**Re: No 4 Frederick Street, St Leonards - Northside Mental Health Facility
(your ref: SSD – 7588) (10 Herbert Street St Leonards - Lot 2 DP 12112720)**

SUBMISSION - PROPOSAL FOR NORTHSIDE MENTAL HEALTH FACILITY (YOUR REF: SSD – 7588)

ON-SITE DETENTION SECTION A
SCALE 1:20

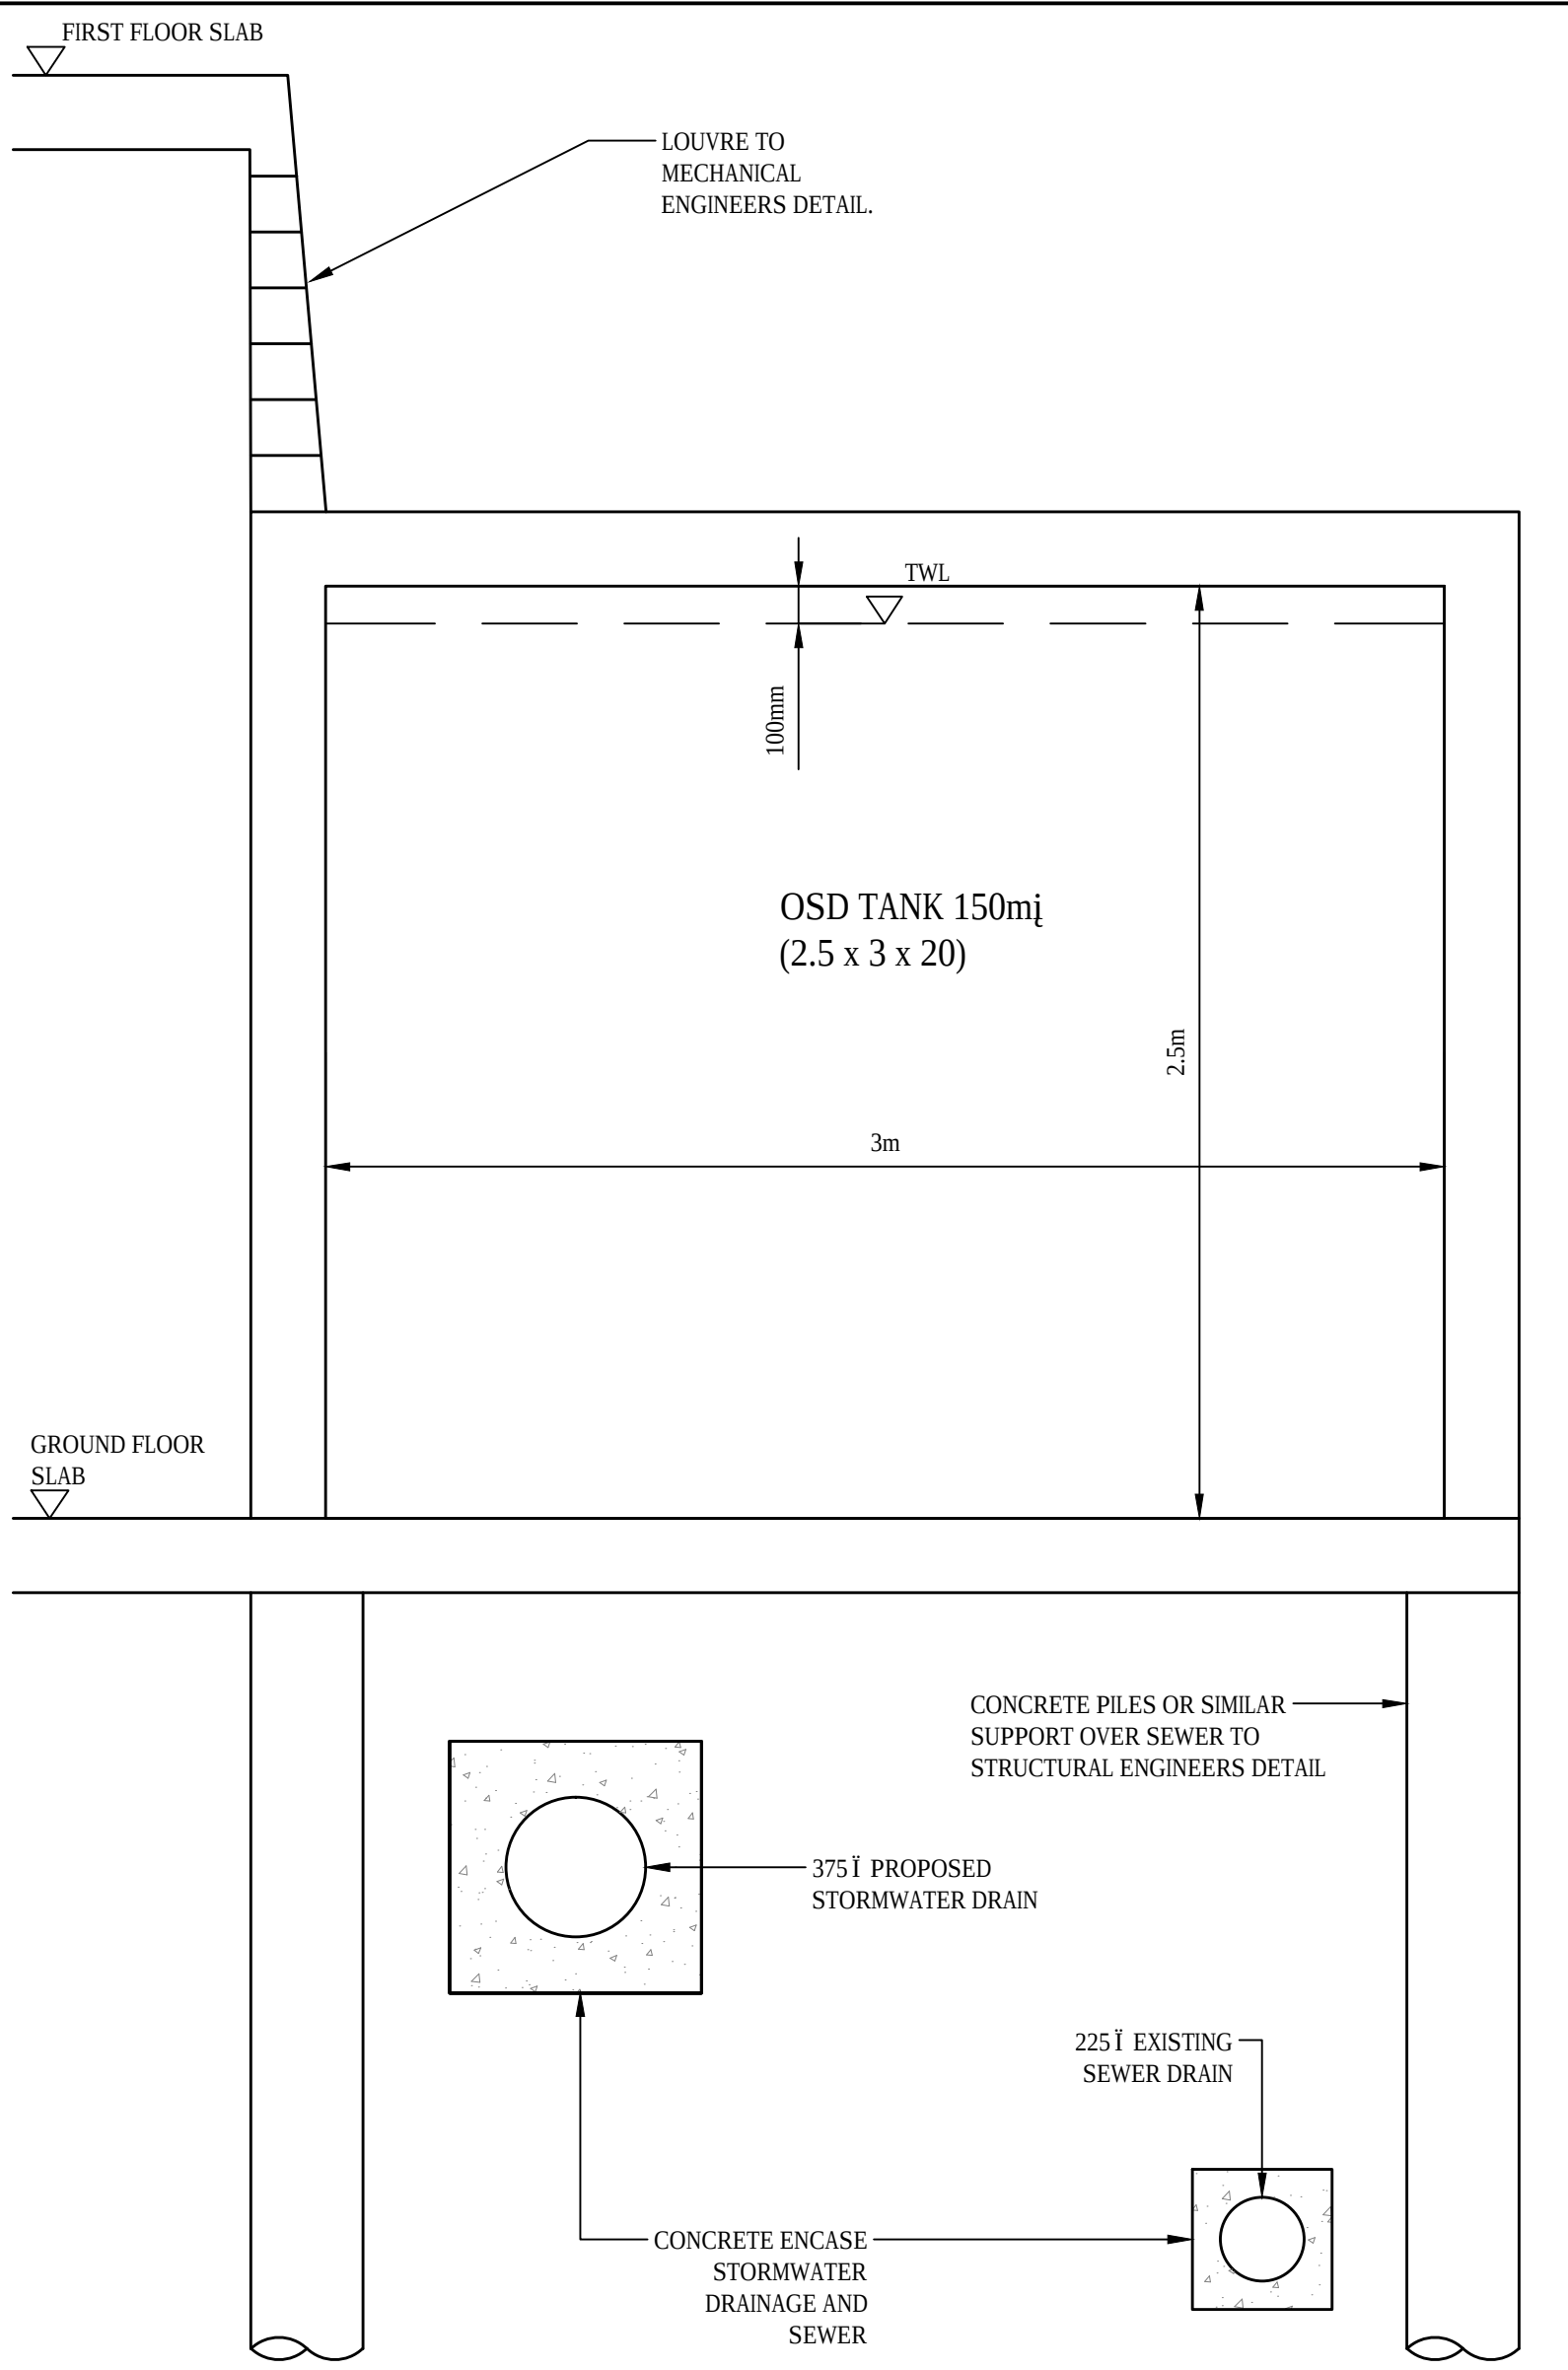
The stormwater management plans submitted with the SSD are considered inadequate and inaccurate in their current form. The stormwater drainage management plan should be redesigned in order to allow the overflow of the proposed on site detention system to be discharged to Frederick Street without causing any extra runoff to downstream properties as there is no underground pipe system fronting the proposed development.

ELEVATION - NORTH

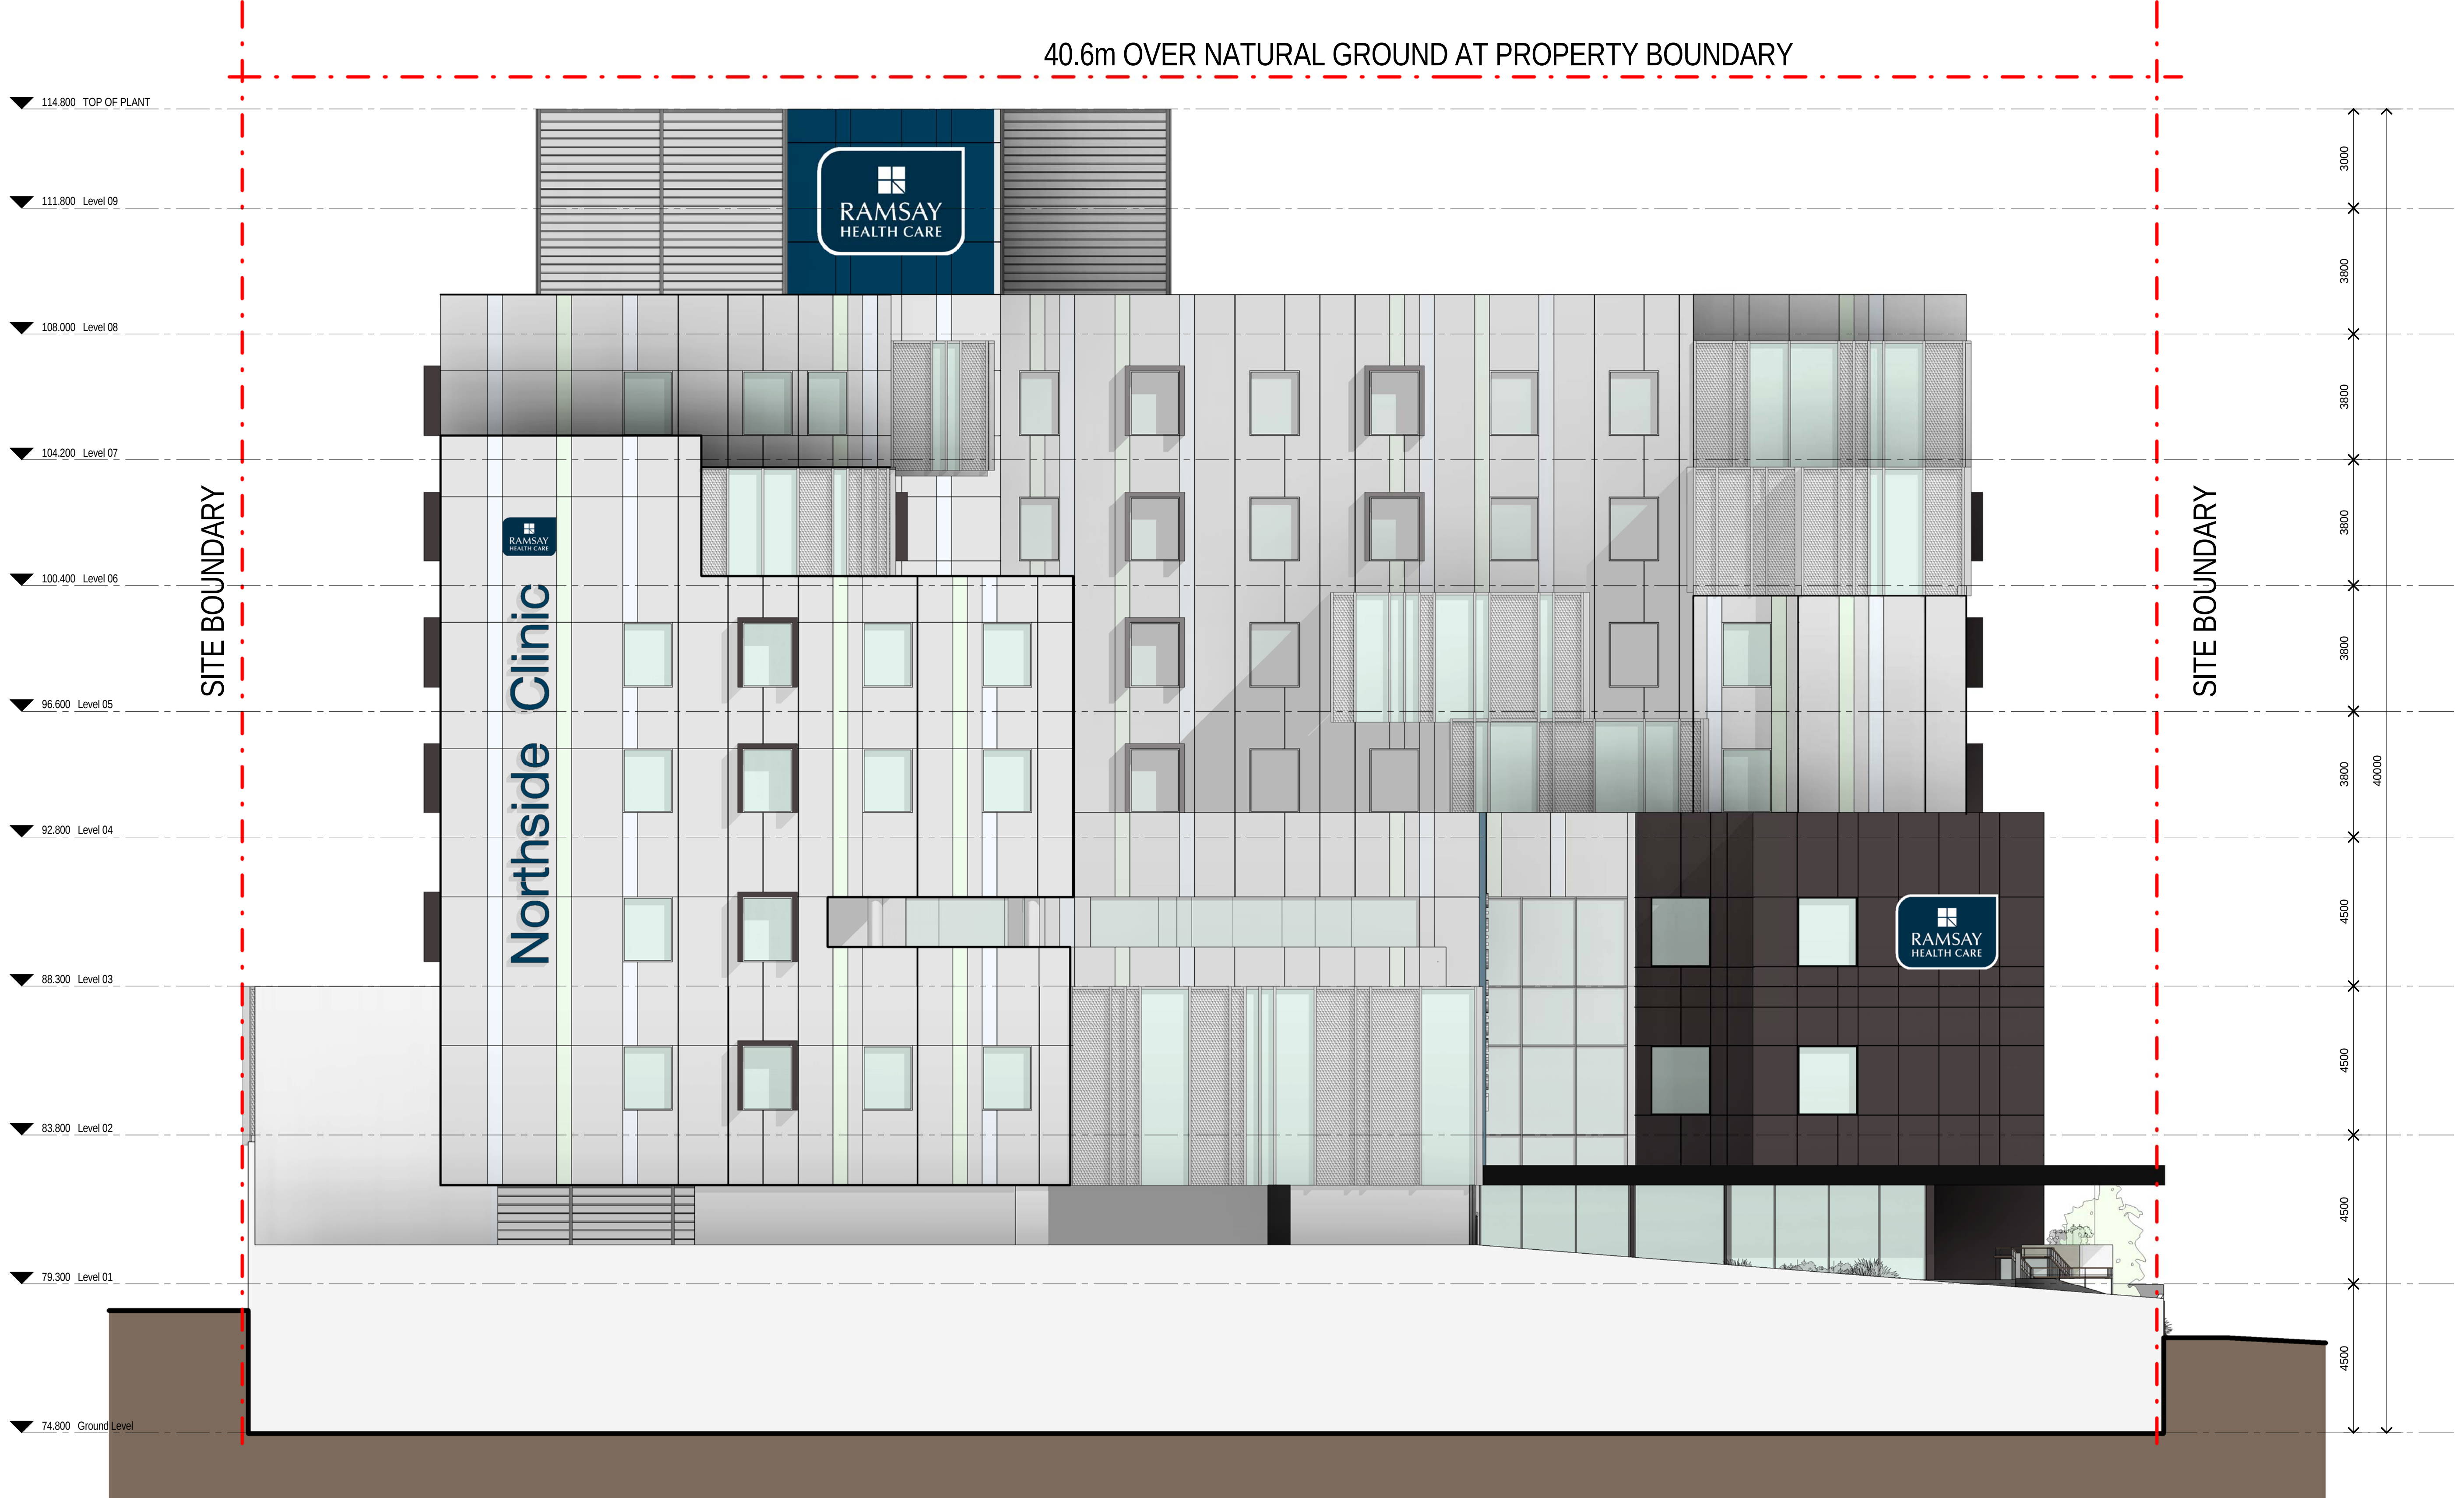
In this regard, the proposed built forms must be well designed to ensure they do not become visually overwhelming, particularly when viewed over lower rise buildings along Herbert Street. The built form should be complementary to the character of the high-tech and light industrial, and hospital precinct of St Leonards. A high standard of urban design outcome is anticipated for the subject precinct as described in *Part F.3.9 of the Willoughby Development Control Plan - Planning Principles for Certain IN2 Land in Artarmon and St Leonards*.

The proposed L-shaped built forms provide a visually interesting forecourt addressing Frederick Street. However, the proposed building has limited setbacks and building modulation along its south-eastern and western elevations. Considerations should be given to a podium – tower treatment to the proposed built forms to allow for a better transition of scale between the proposed building and surrounding developments. A podium level will also provide additional outdoor spaces and improved outlooks and amenity for rooms facing the side and rear elevations over adjoining industrial developments.
